Your Ref: OWPC21846
Our Ref: M/24/19/PL 06-03-2019
Please ask for:
Andrew Wood

Replacement residential dwelling. This application may affect a Public Right of Way.

3 The Hard Elmer

REV.	DESCRIPTION	DATE
1	PROJECT REPLACEMENT DWELLING 3 THE HARD ELMER SANDS WEST SUSSEX	
2	CLIENT Ms D HUANG	
3	DRAWING TITLE PROPOSED PLANS, ELEVATIONS & SITE PLAN - DRAFT ISSUE ONLY	
4	SCALE VARIOUS @ A1	DRAWN BY MUM
5	DATE JAN 19	
6	DWG NO PLO1	REV. /

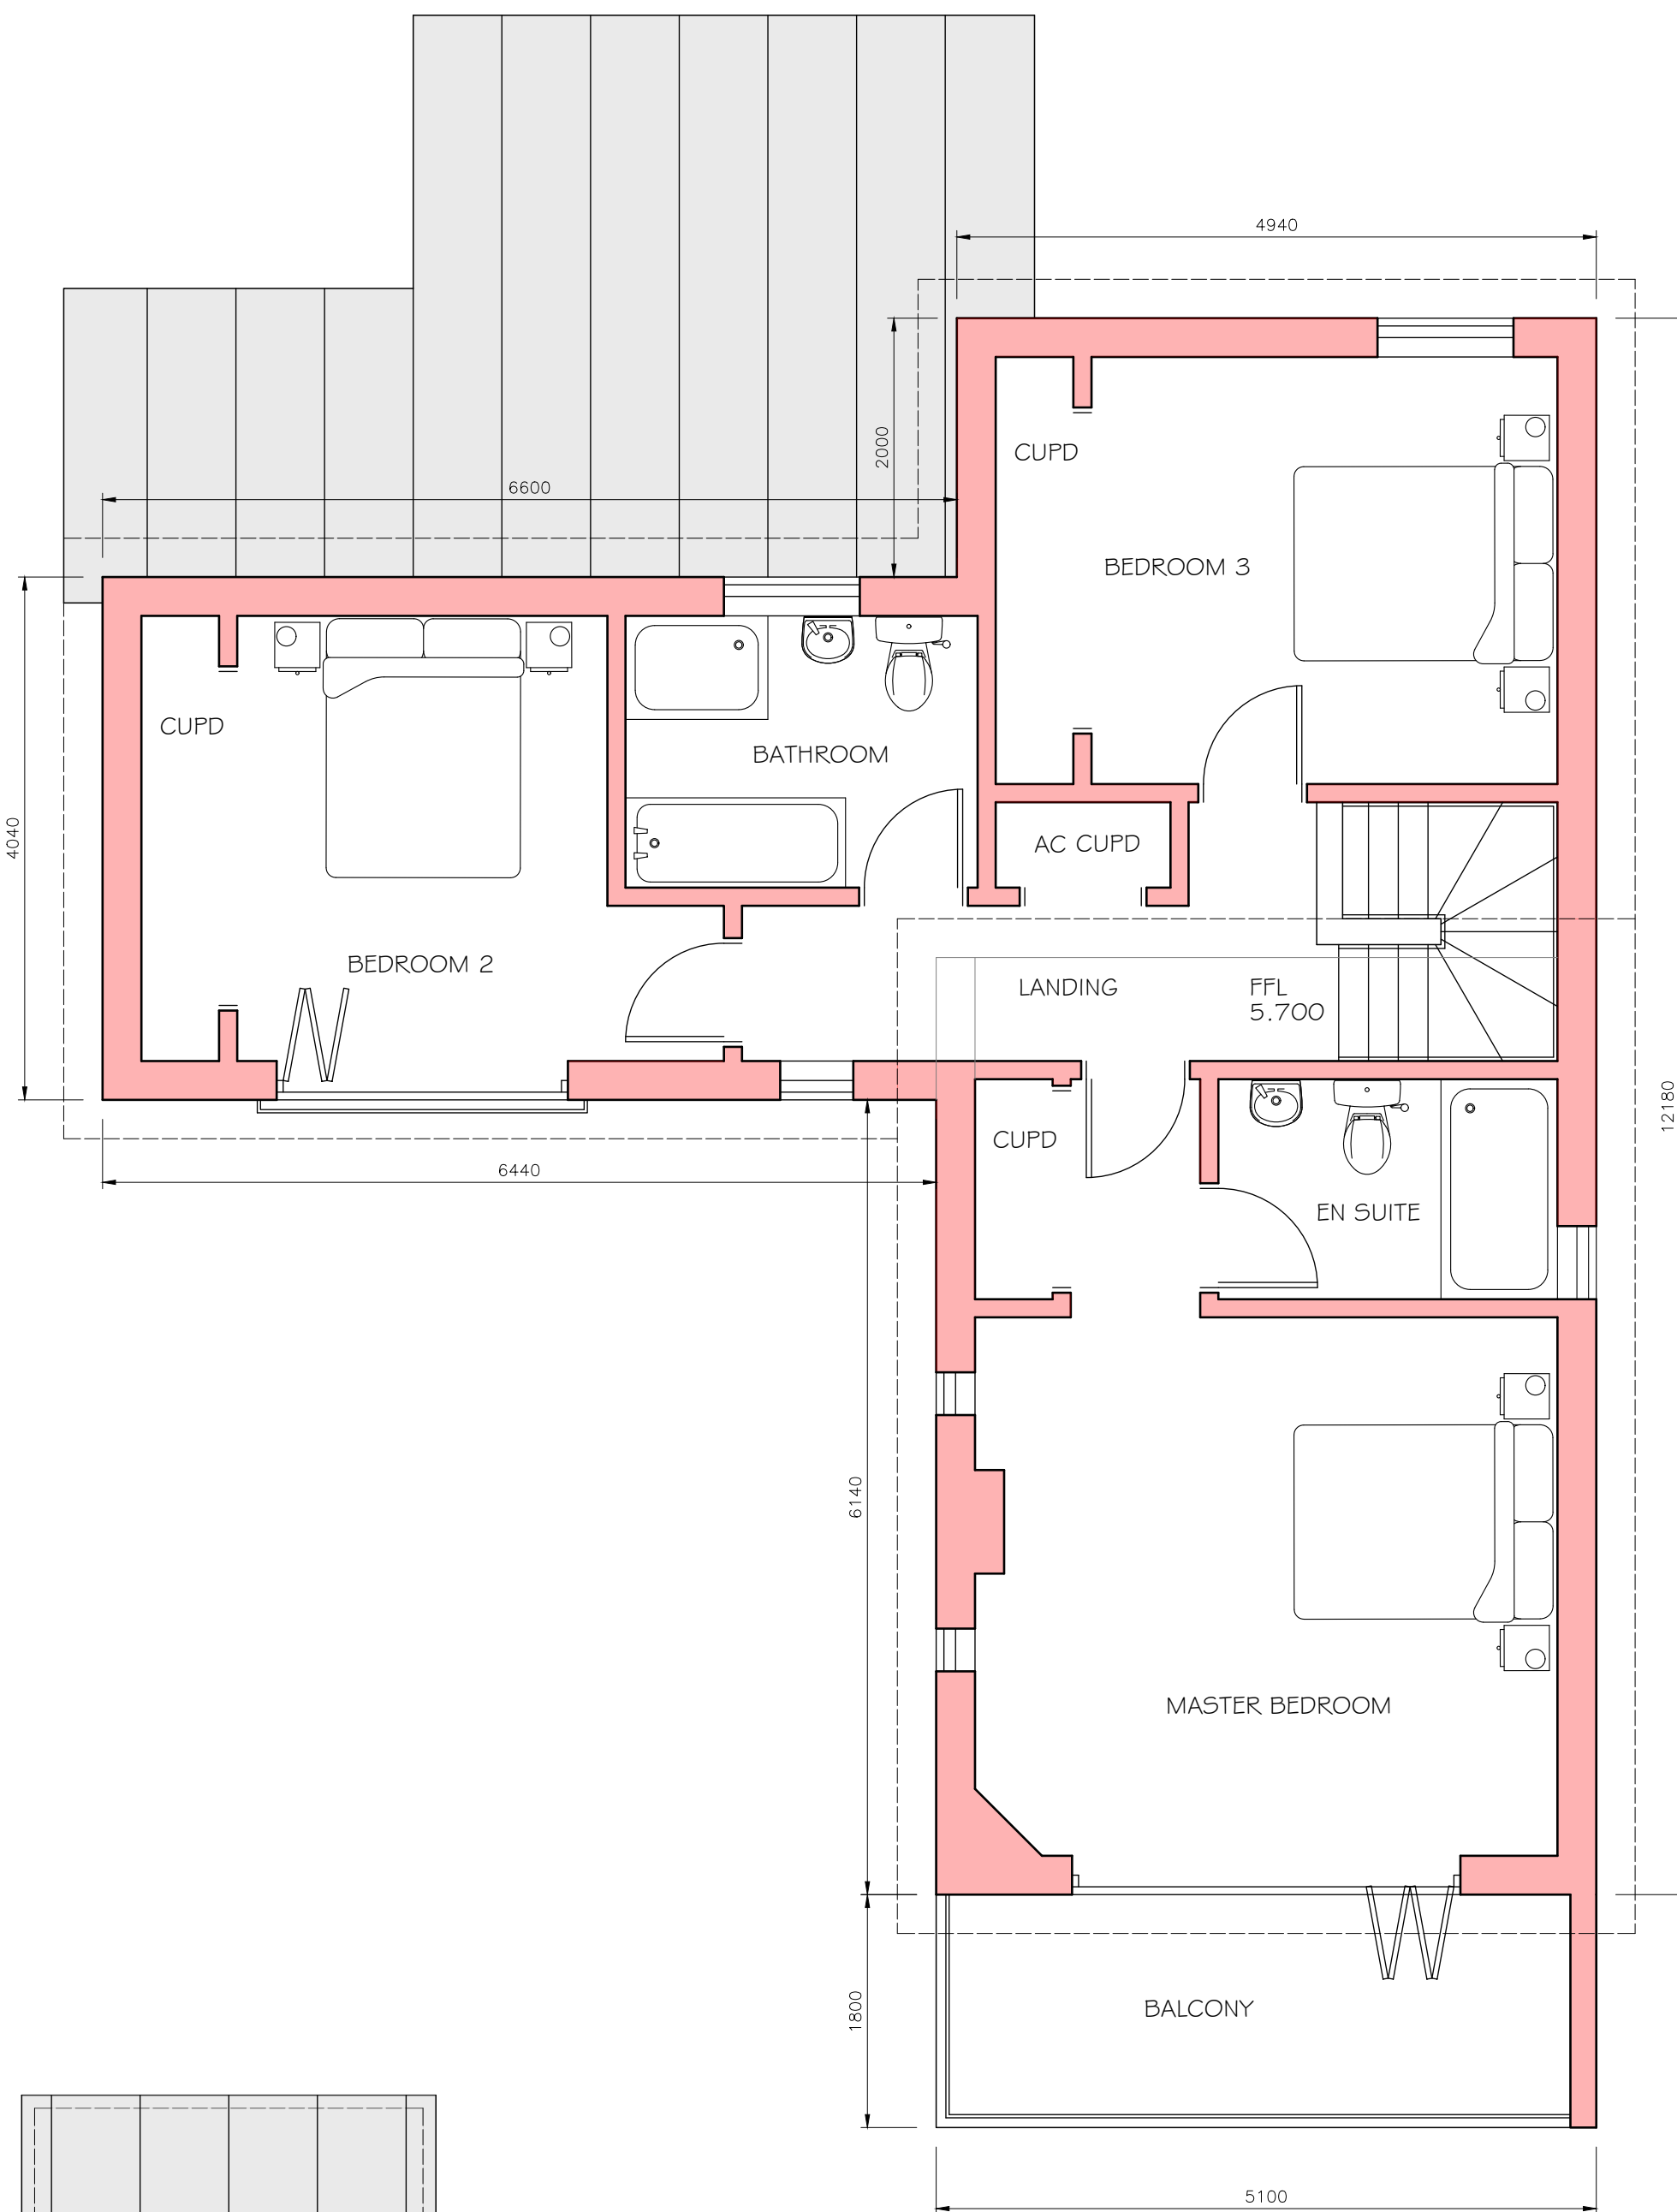
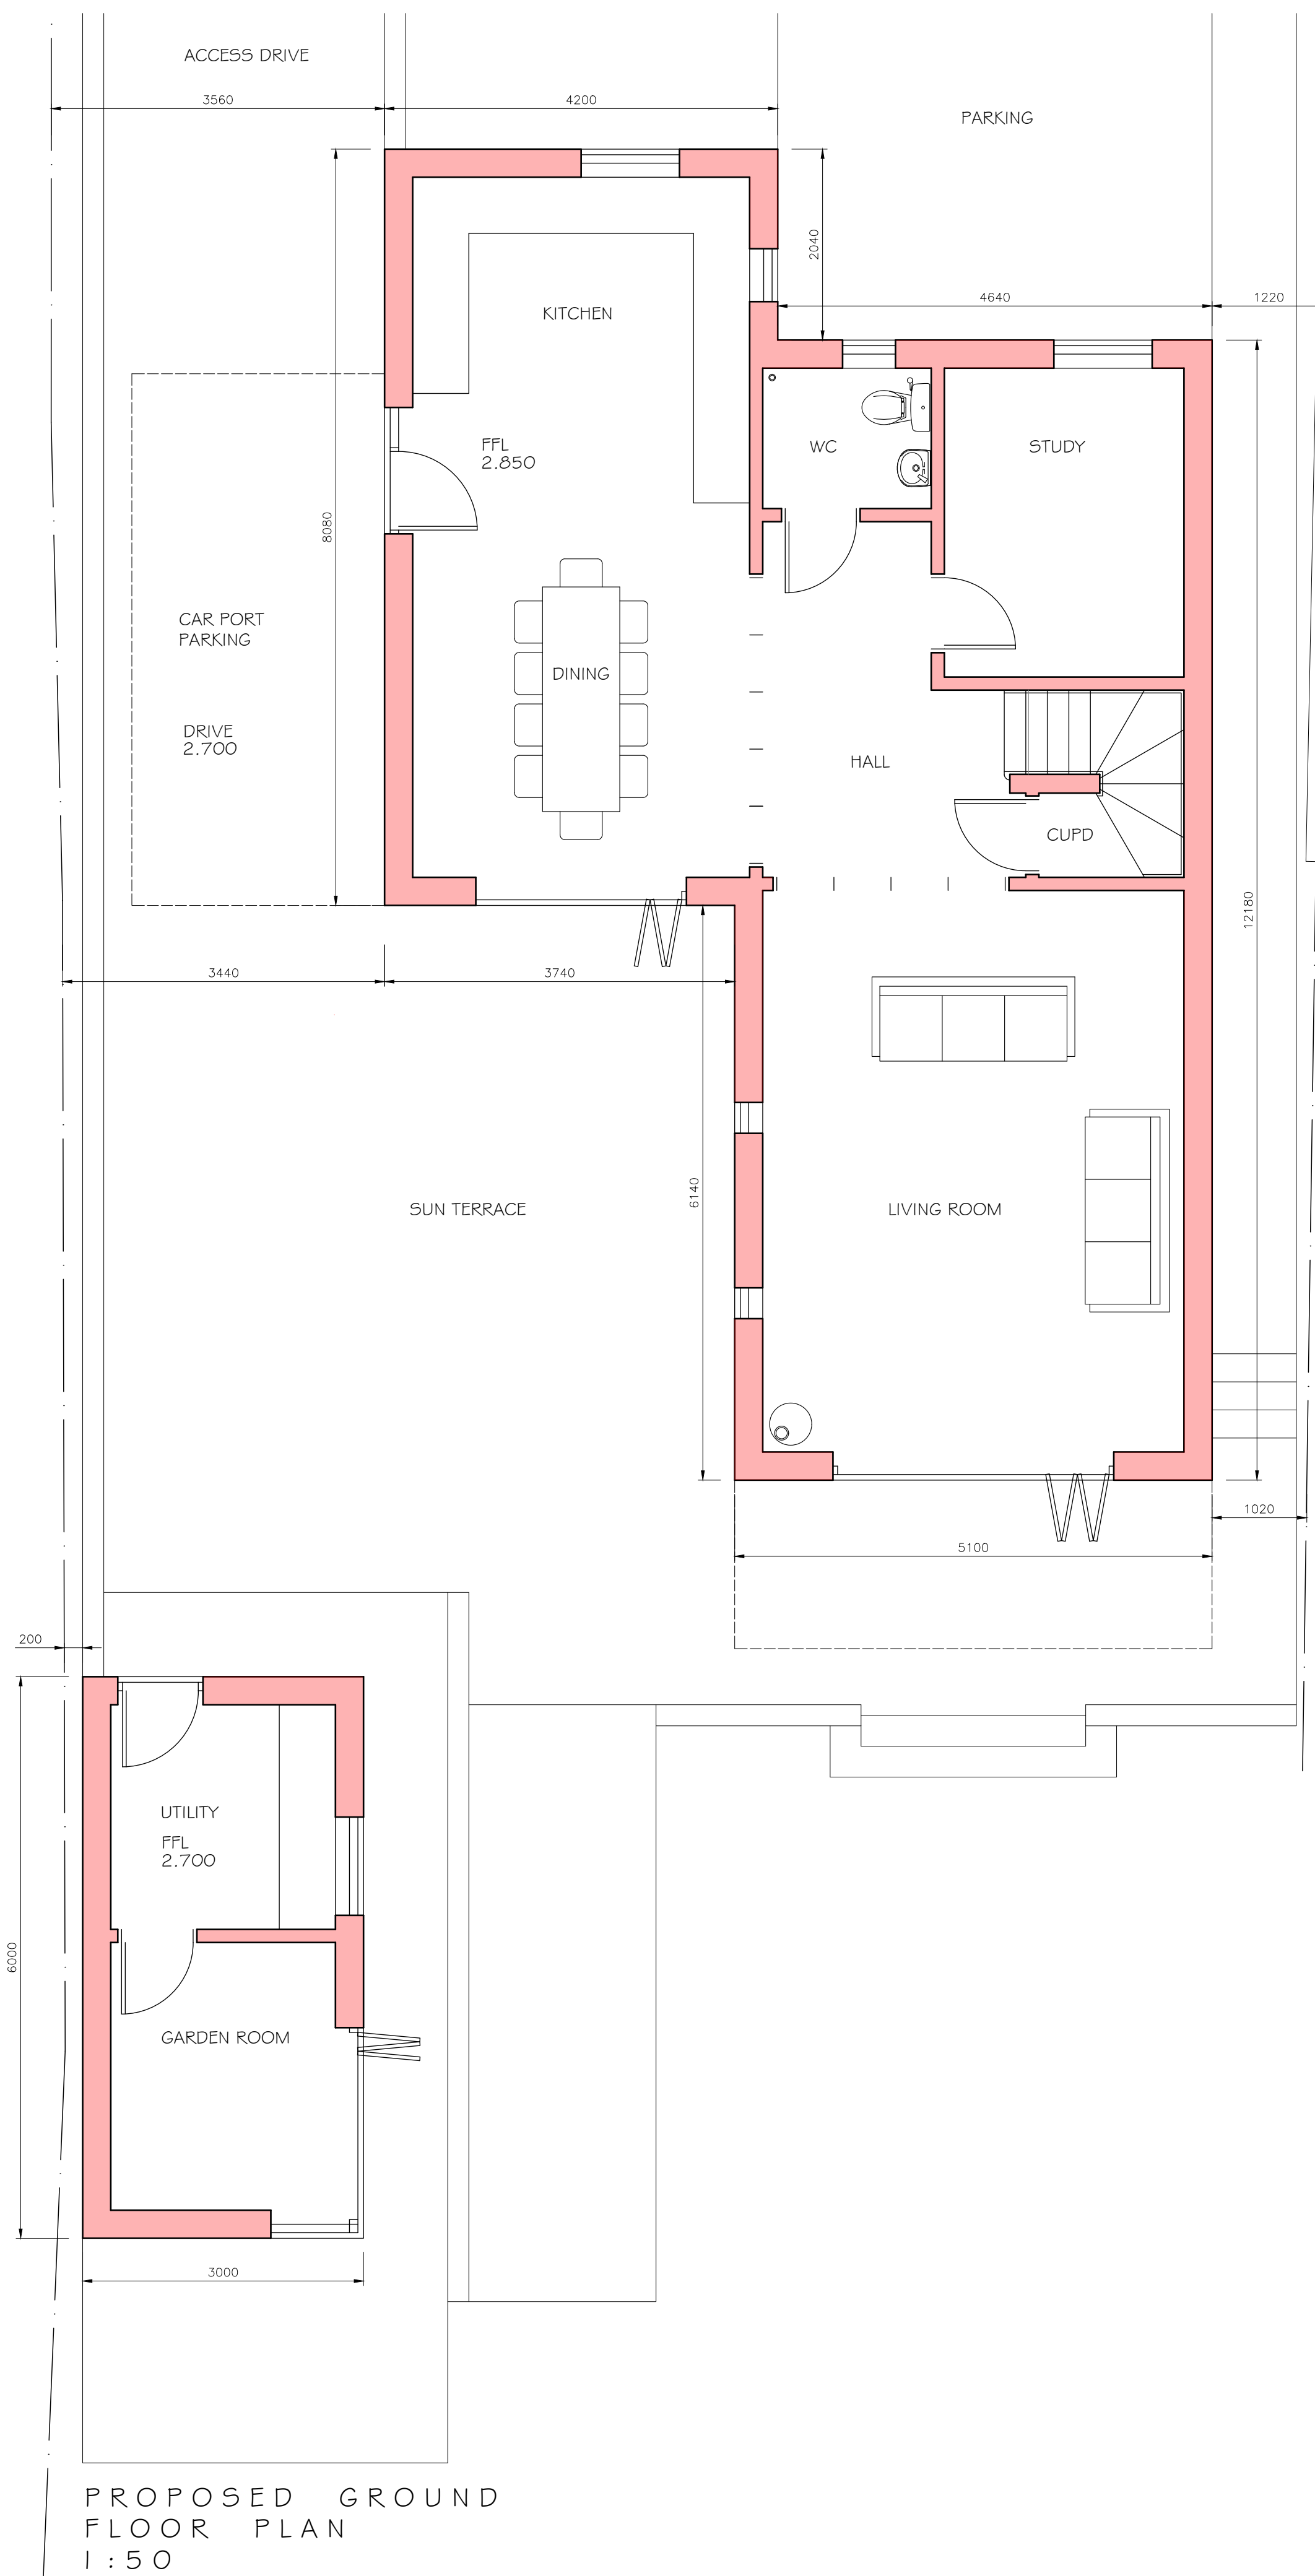
The proposed site plan 13/03/2019 shows the intention to modify or remove the floodbank - 'raised garden feature reduced in height'

Therefore the flood bank in the garden should not be flattened or modified, unless it is to increase its height.
